From: [REDACTED]
Sent: 09 September 2013 07:07
To: Planning
Cc: [REDACTED]
Subject: number 4 wilkins green lane objections
Attachments: 4 Wilkins Green Lane development.docx

5 Wilkins green Lane
Hatfield
AL10 9RT

Planning reference **S6/2013/1469/FP**

TITLE Proposed Ground & First Floor Plan		
PROJECT NAME Oak Cottage, 4 Wilkins Green Lane, Hatfield, AL10 9RT		
DRAWN BY E.B	DATE SEPT 2013	
SCALE 1:100 @ A1	CHECKED	
DRAWING NO. EL/2012/05	REV. NO. E

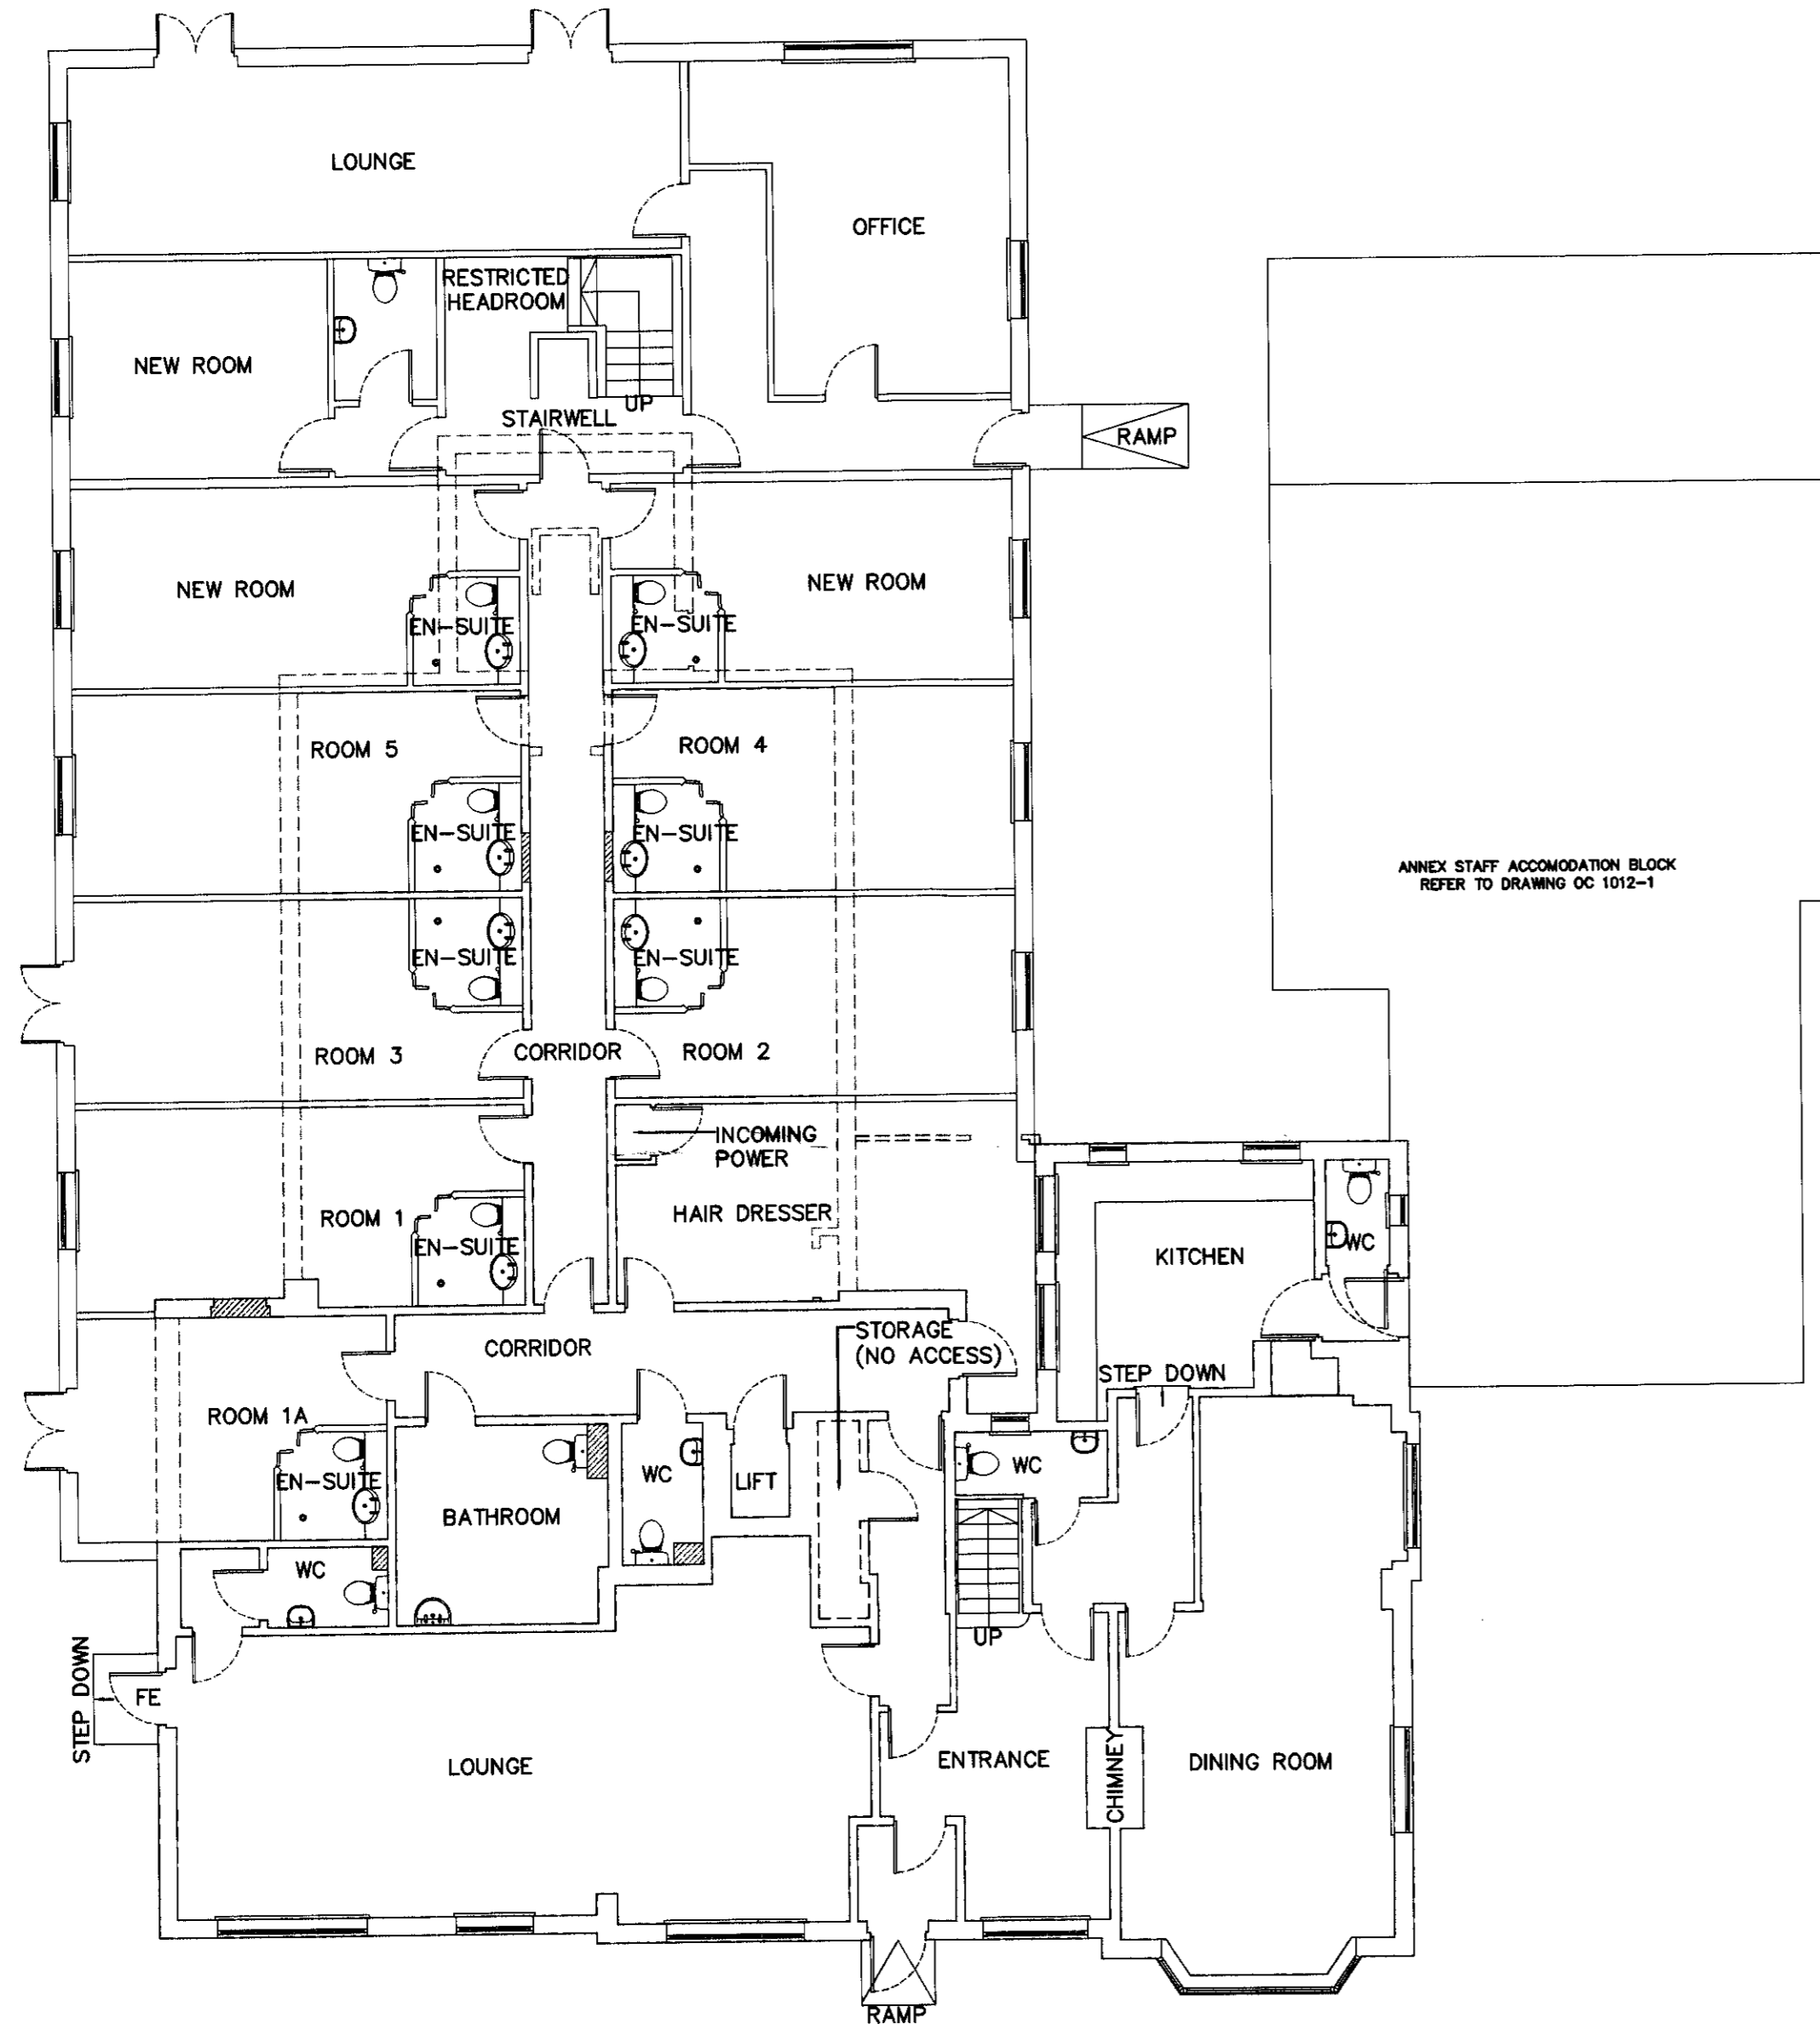
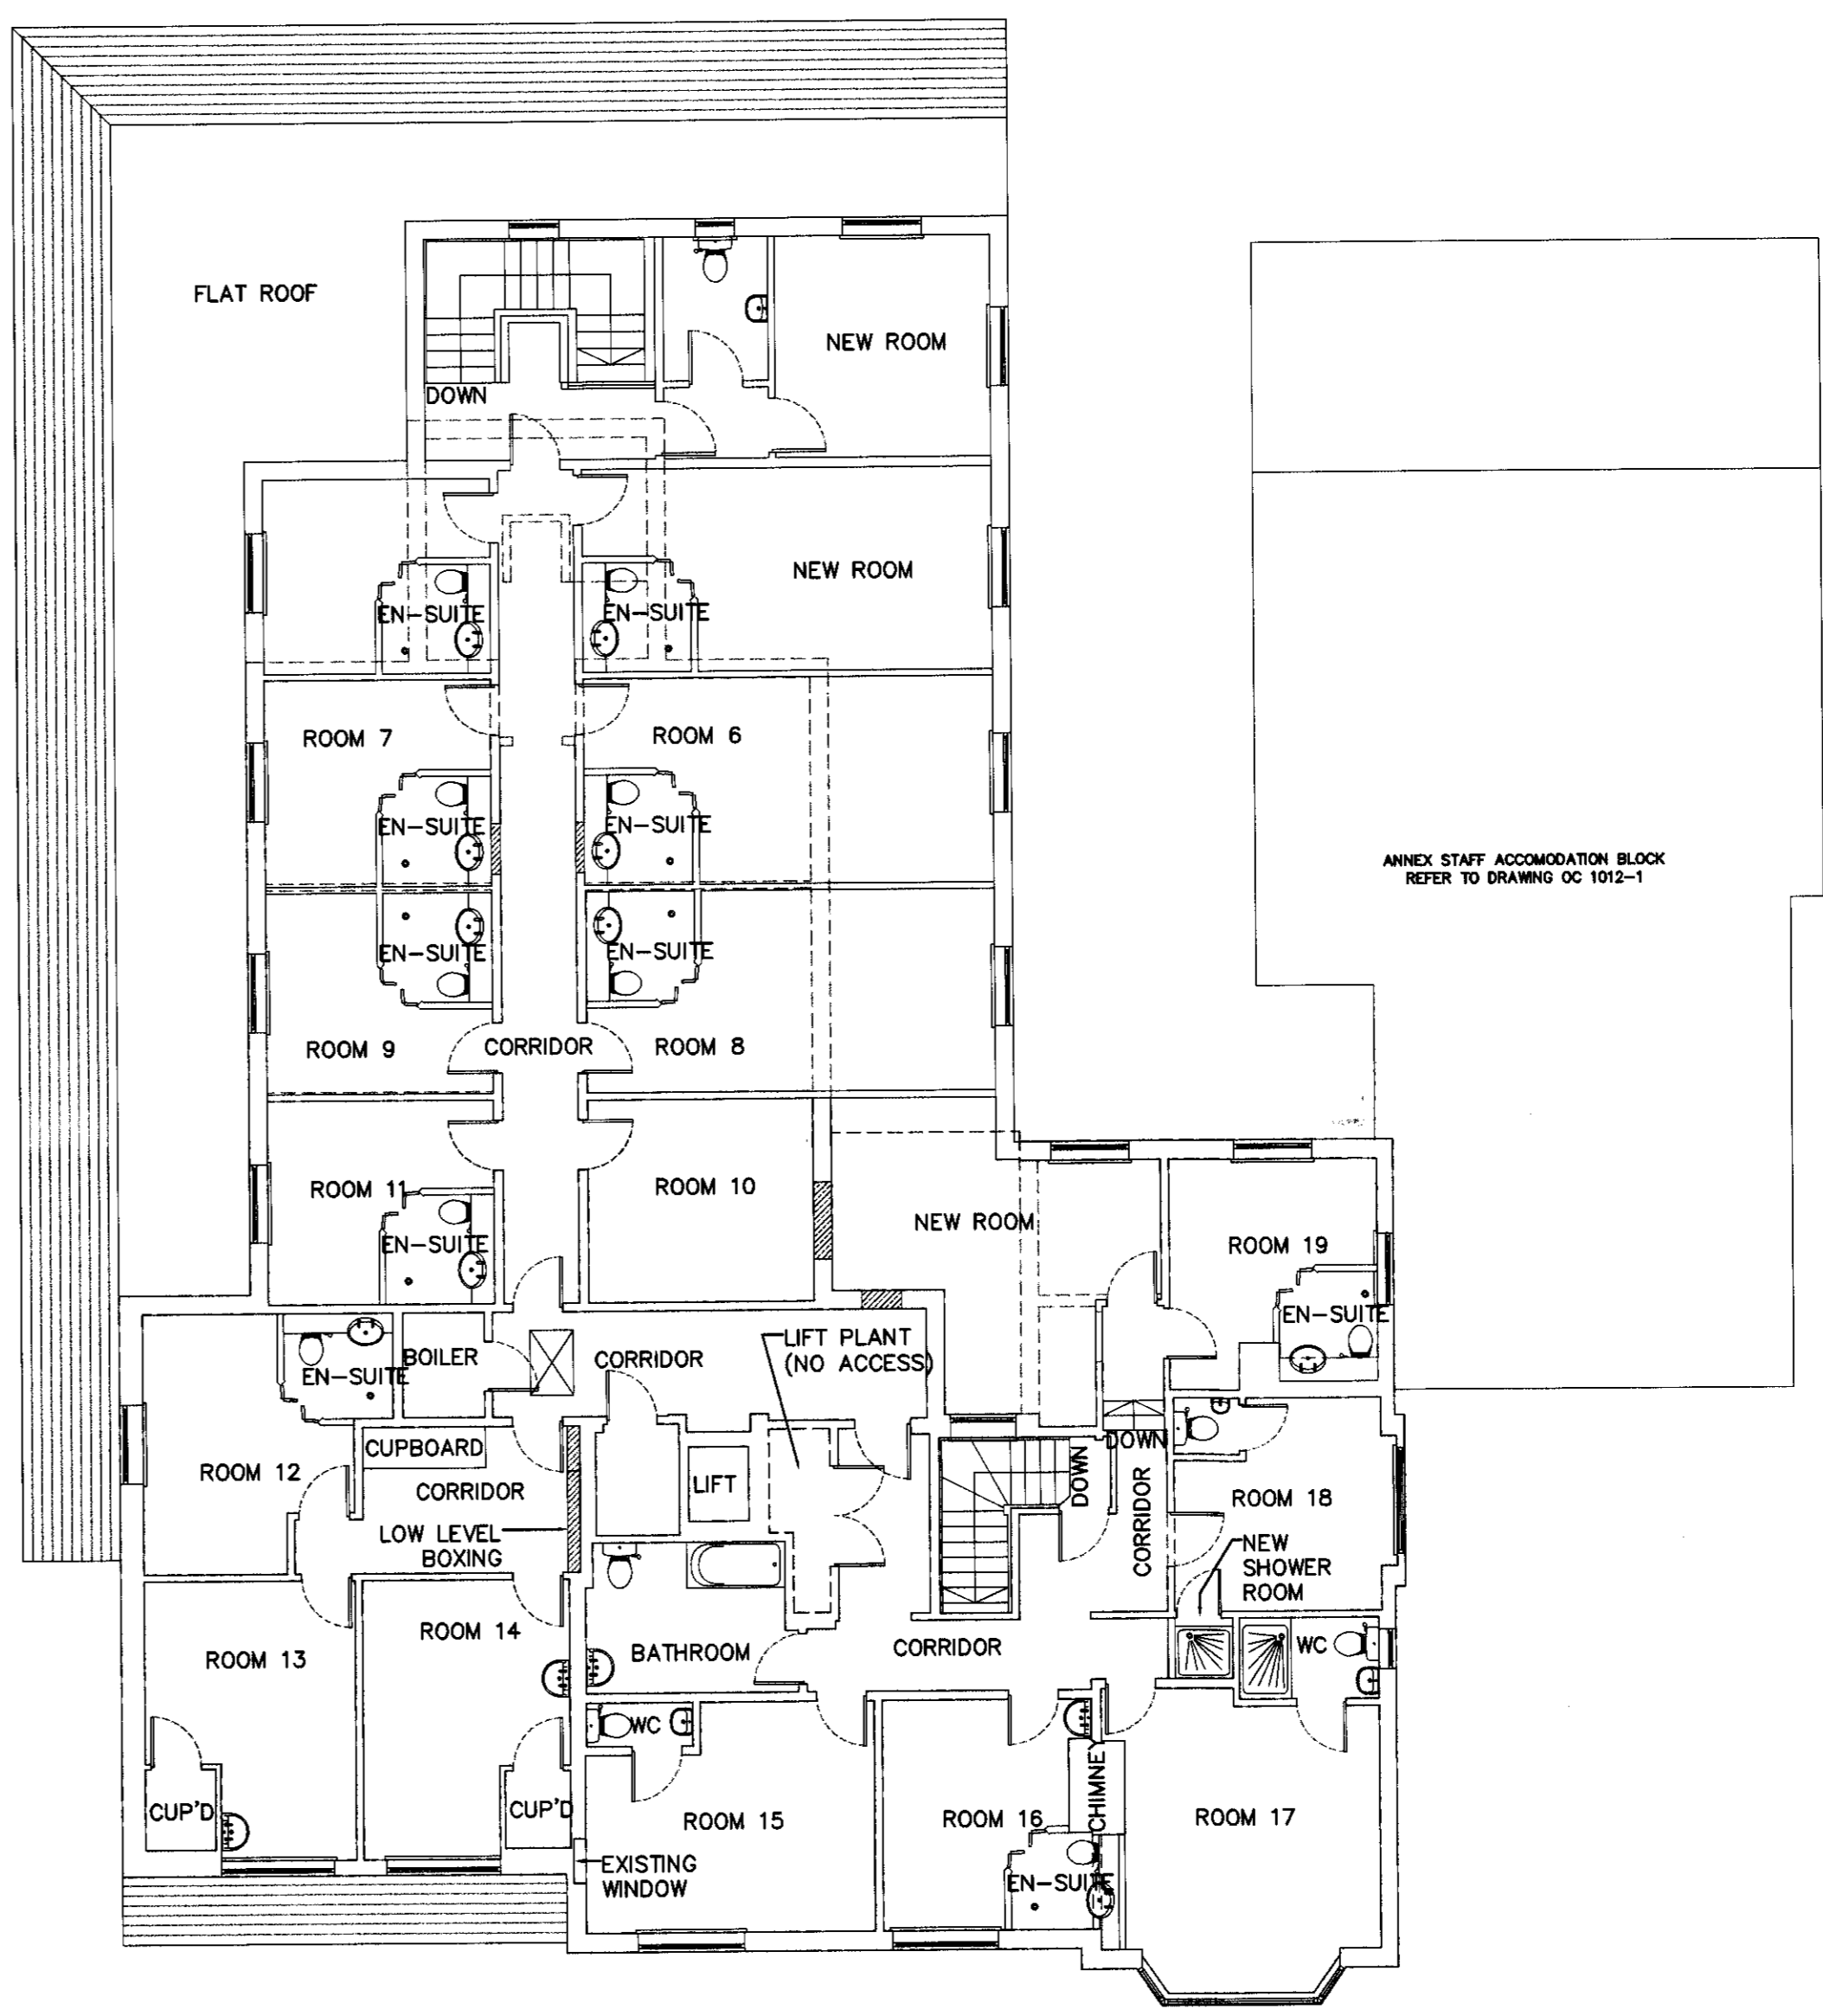
2. **Privacy:** This application again has side windows of clear glass. The 2007 application did not have additional side windows. The application repeats from the letter earlier this year that *"the building will not have a detrimental impact on the neighbours as windows will be positioned the same as the existing elevation"*. This does not make sense- the application proposes additional clear windows beyond the current building lines looking into the gardens of adjoining properties. It also states that *"the elevation to number 6 is shielded by a high conifer hedge"* but the site does not adjoin number 6. At the very least we would ask that a standard condition should be imposed on side windows that they *"shall be glazed with obscured glass and shall be fixed so as to be incapable of being opened below a height of 1.8 metres above floor level, and shall be retained in that form thereafter."*

3. **Character:** The new proposal is to build on a significant part of the garden of the house at the back and to change the landscaping at the front into a car park for 16 vehicles. This is unacceptable and completely out of character with the surrounding properties. Also this extra flow of traffic on such small lane poses a risk to the community
